## Appeal Decision

**Appeal Ref: APP/R5510/D/21/3276162**

**4 Harvil Road, Ickenham UB10 8AJ**

- The appeal is made under section 78 of the Town and Country Planning Act 1990 against a refusal to grant planning permission.
  - The appeal is made by Mr J Hayer against the decision of the Council of the London Borough of Hillingdon.
  - The application Ref 76195/APP/2021/478, dated 3 February 2021, was refused by notice dated 10 May 2021.
  - The development proposed is part single storey/part two storey side and rear extension incorporating roof alterations. Widening of existing vehicular access.
-

PROPOSED FIRST FLOOR PLAN
1:100

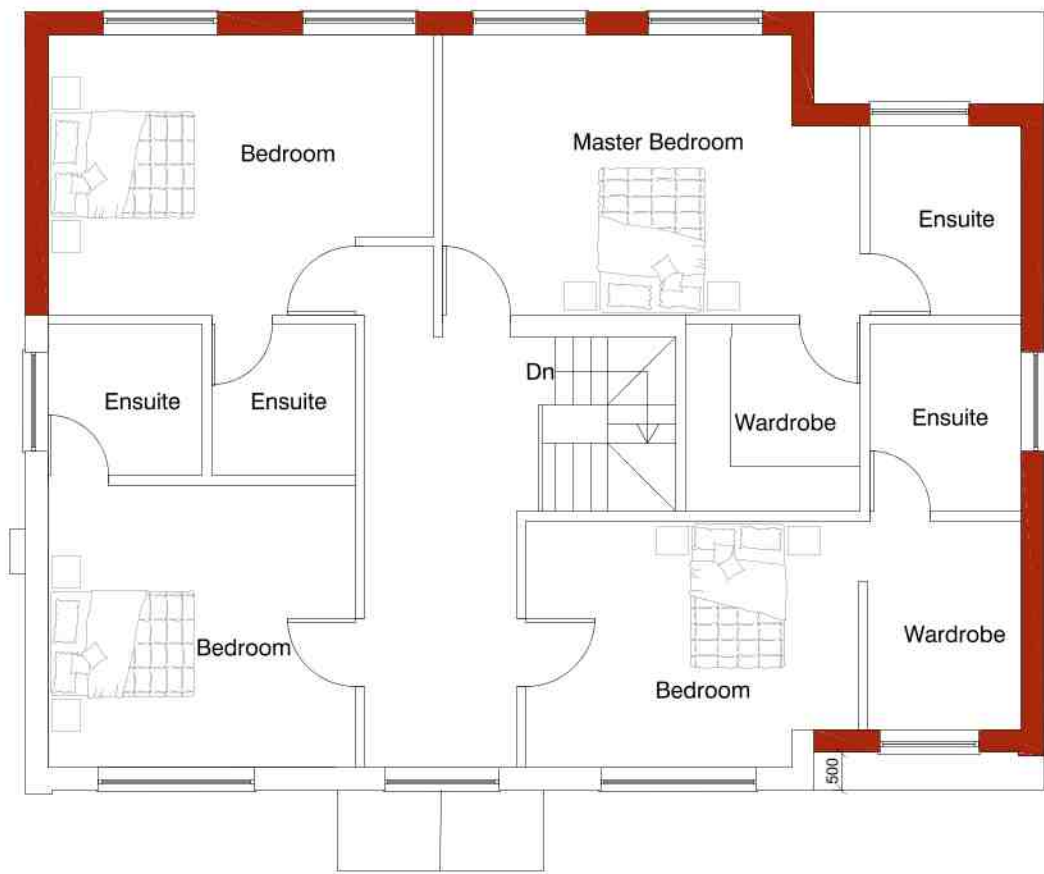
4. The appeal proposal would entail the construction of a part two storey/part single storey side extension that would be set-in about 0.5m from the front elevation at first floor level and set back from the common shared side boundary. The two storey extension would extend across the full width of the house and would be stepped down below the ridge of the host property with a hipped tiled roof. The proposal would also involve the construction of a single storey flat roofed rear extension and a new hipped roof over the main house.

7. As such, although set in at first floor level and stepped down at roof level, the proposed side extension and the new hipped roof, would result in substantial bulk at the side and over the main dwelling that would be out of character with the more modest traditional form and appearance of the host building.

PROPOSED FRONT ELEVATION
1:100

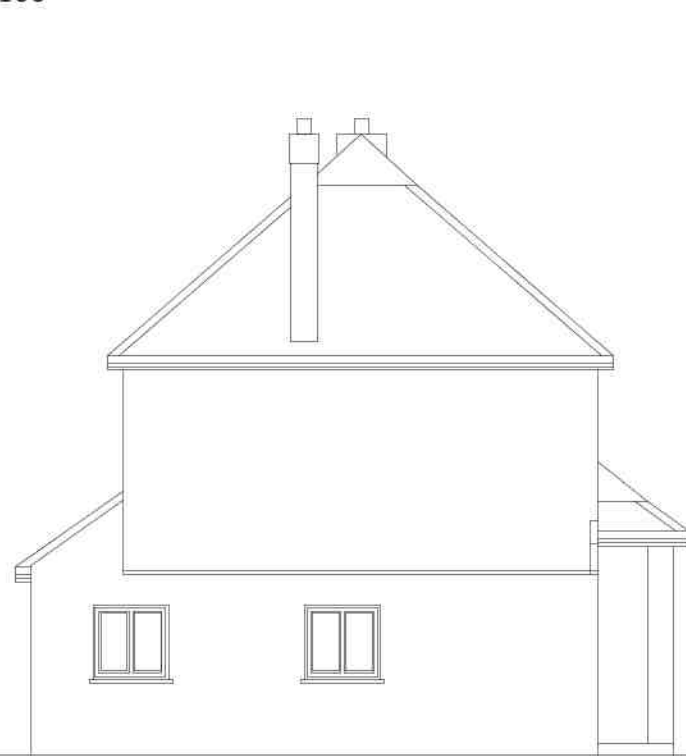
6. The appeal property is on a relatively spacious plot and as such the extensions would not appear overlarge, relative to the overall plot size. Whilst the new hipped roof over the main house would have a comparable ridge height to the host property and would be seen in the context of the current varied roof heights of the surrounding properties, the scale and form of the proposed two storey side extension built in line with the front of the main house and the new hipped roof would nevertheless still be a significant addition relative to the main property.

8. These shortcomings would be exacerbated by the proposal's prominent position, where the proposed side extension and new hipped roof would be visible from a number of public vantage points along Harvil Road. The proposed two storey side extension and roof alterations, by virtue of their scale, siting and design, would fail to achieve an appropriate degree of subordination to the host property and would detract from its architectural integrity. As such, I consider that the proposed side extension and roof alterations would result in incongruous and out-of-keeping additions that would cause unacceptable harm to the host property and the area.

PROPOSED SIDE ELEVATION
1:100

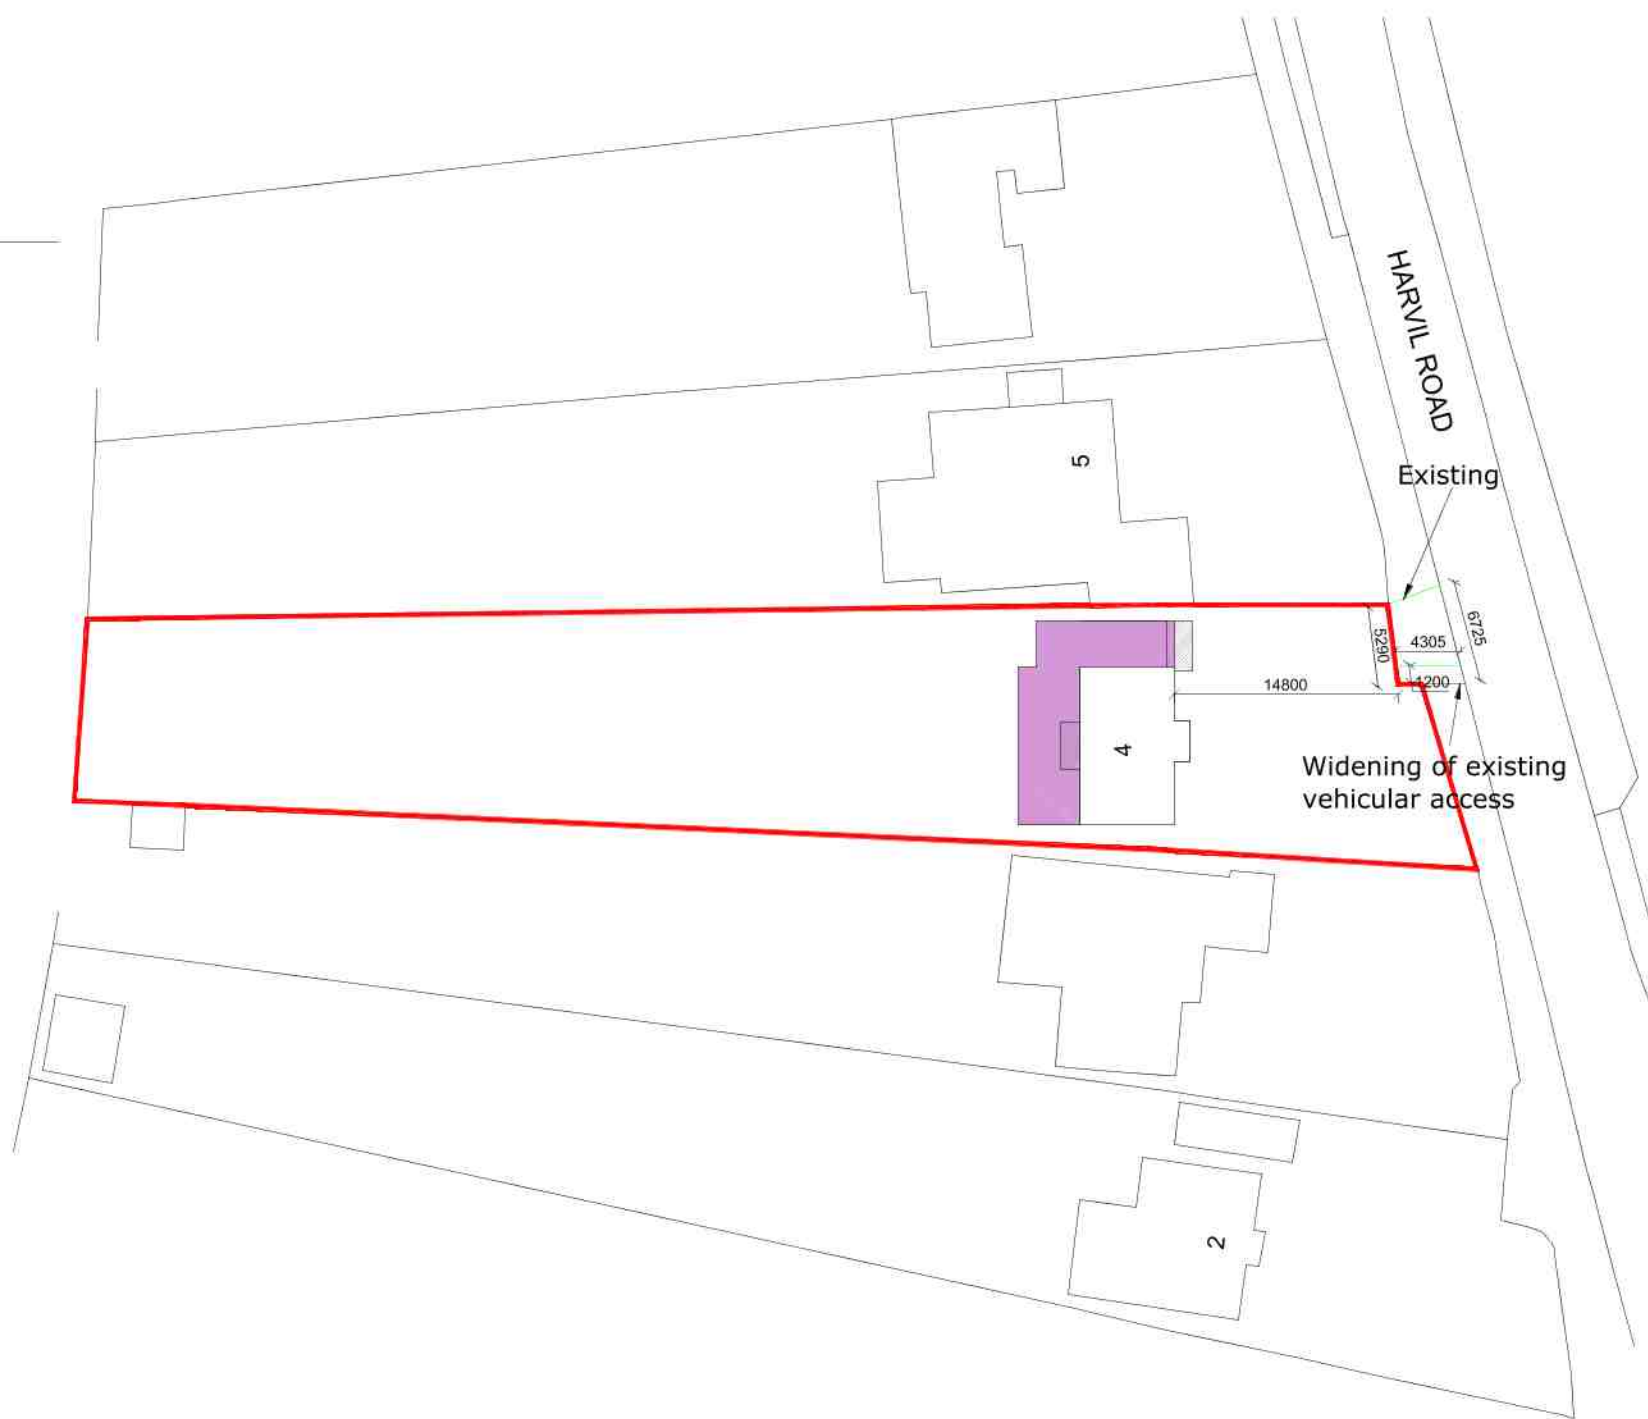
5. Policy DMHD1 of the Hillingdon Local Plan Part 2 Development Management Policies 2020 states that two storey side extensions and alterations should be subordinate to the main dwelling. Policy DMHD1 specifies two storey side extensions should be set back a minimum of 1m behind the front elevation of the house and stepped down below the main ridge in the order to ensure they are subordinate to the main house. Policy DMHD1 also specifies that the raising of a main roof above the existing ridgeline will generally not be supported.

10. Consequently, I conclude that the proposed two storey side extension and roof alterations would adversely harm the character and appearance of the host property and the area. It would be contrary to the overall design aims of Policy BE1 of the Hillingdon Local Plan: Part 1 Strategic Policies 2012 and Policies DMHB11, DMHB12 and DMHD1 of the Hillingdon Local Plan Part 2 Development Management Policies 2020. These policies, amongst other things, seek to ensure that development proposals, including residential extensions, will be of a high standard of design that harmonise with the local context and make a positive contribution to the local area in terms of layout, form, scale and materials.
